OXFORDSHIRE COUNTY COUNCIL'S RESPONSE TO CONSULTATION ON THE FOLLOWING DEVELOPMENT PROPOSAL

Application no: 21/03644/OUT

Proposal: Erection of up to 49 dwellings, associated open space, sustainable urban drainage systems, and access from Balmoral Avenue

Location: OS Parcel 6372 South East of Milestone Farm, Broughton Road, Banbury

JOB TITLE		Balmoral Avenue		CLIENT	Lone Star Land Ltd
DRAWING TITLE					
Illustrative Masterplan					
Vehicle Tracking (Refuse and MPV)					
SCALE	DRAWN BY	DATE	DRAWING NO	REVISION	
1: 500 @ A3	DN	Oct 21	23158-04-1

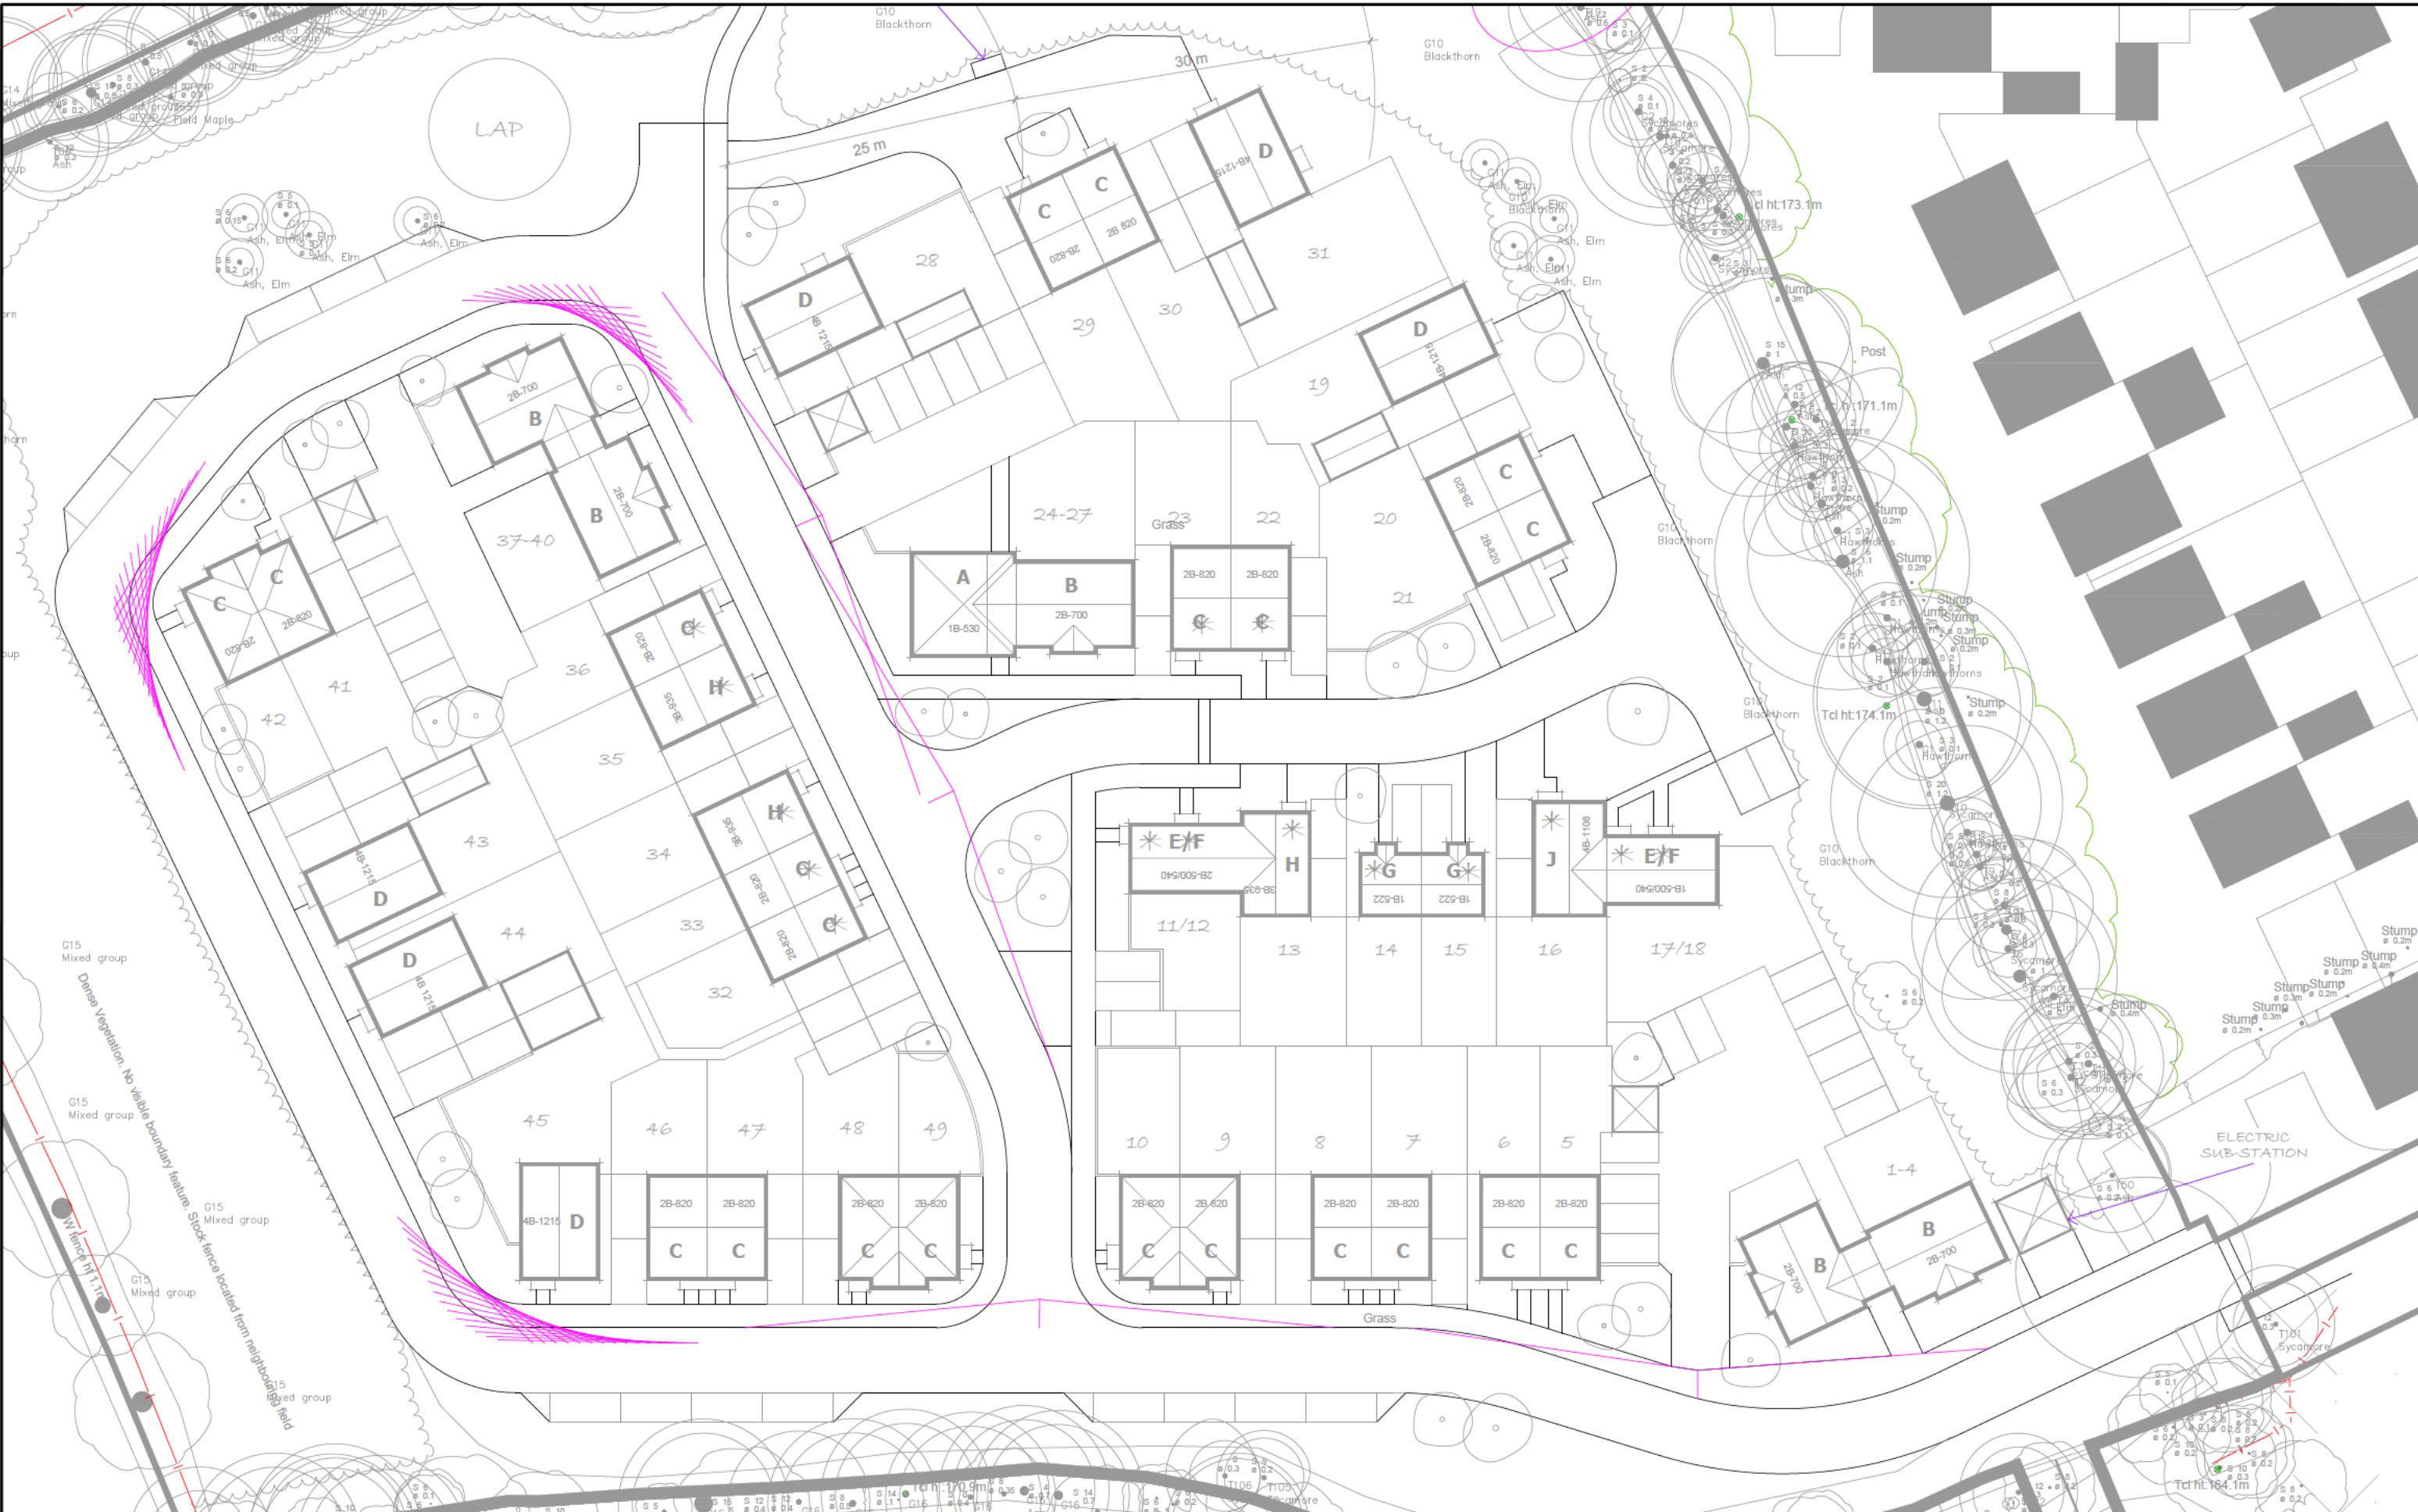
- The new tie-in to the existing road will create a straight section greater than the 70m recommended allowance. A traffic calming feature should be introduced on Balmoral Ave.

- The Service corridor will need to be a minimum 2m wide under the footway or verge.
- There are no visibility splays indicated. Junction and Forward Visibility Splays must be in accordance with the County's Design Guide and dedicated to the County if they fall out of the existing highway boundary.

- The County requires a swept path analysis for an 11.6m refuse vehicle for all manoeuvres in forward gear passing an on-coming or parked family car throughout the layout. The carriageway will require widening on the bends.

- The carriageways that are straight for over 70m will require some form of traffic calming to ensure vehicle speeds are less than 20mph.
- Shared surfaces width will be a minimum of 6m and a minimum of 800mm maintenance margin is required either side of the shared surface. A blocked paved surface or similar will be required for shared surfaces.
